Our ref: KT/2023/130482/01-L01
Your ref: TR020005
Date: 26 October 2023

GATWICK AIRPORT NORTHERN RUNWAY DEVELOPMENT CONSENT ORDER APPLICATION

Relevant Representation On behalf of the Environment Agency

Figure 4.1: Schematic of Museum Field FCA

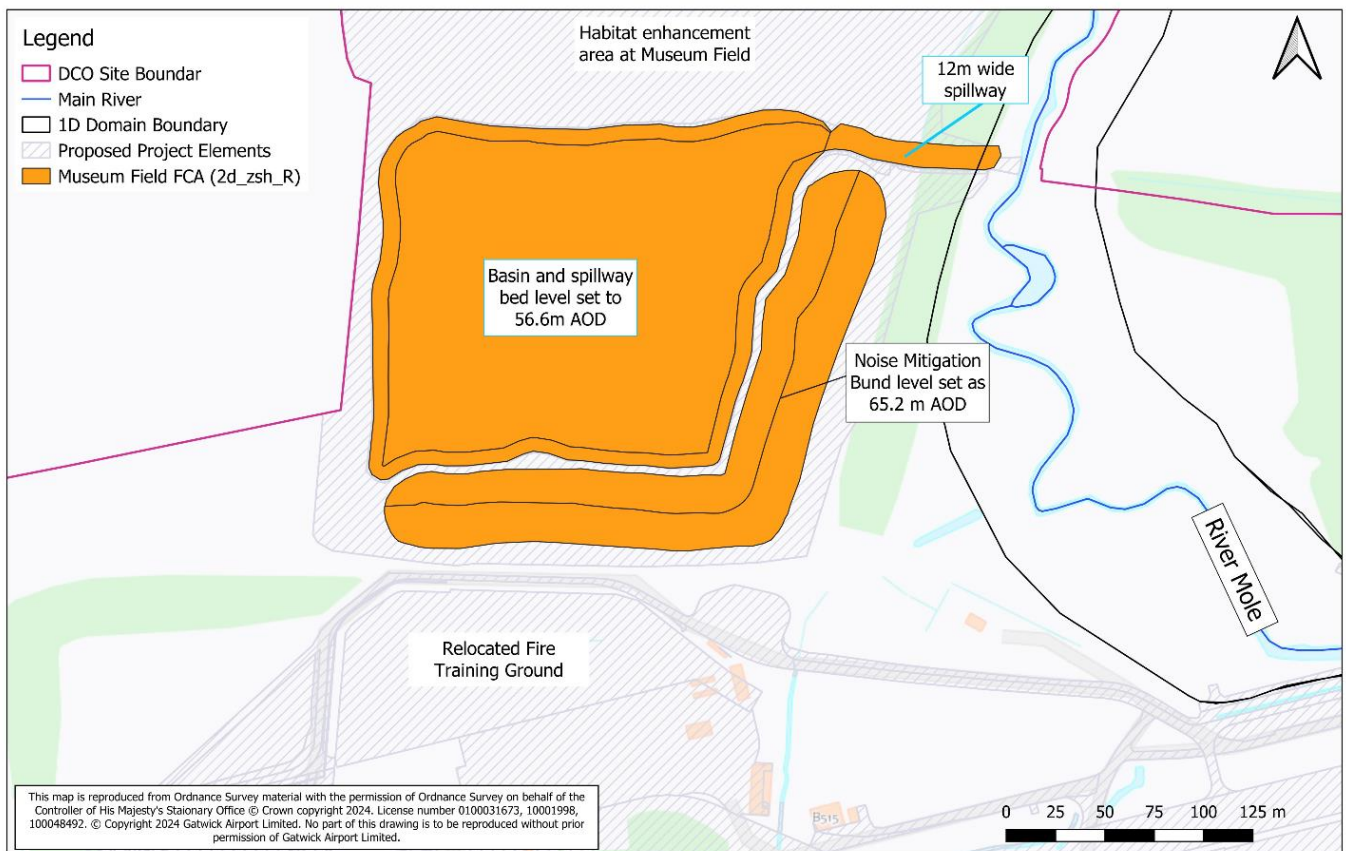
There are existing mature trees situated within in the Museum Field, which were discussed in a previous joint consultation meeting whether these might be retained and could be assessed for compatibility with the function of that flood compensation feature.

The landscaping plans refers to a clear space with new grassland being created within the flood compensation area and note the landscaping design approach which will test the suitability of existing habitat features for incorporation and retention. However, it remains unclear about the fate of these trees within the Museum field flood compensation area, and therefore request clarification.
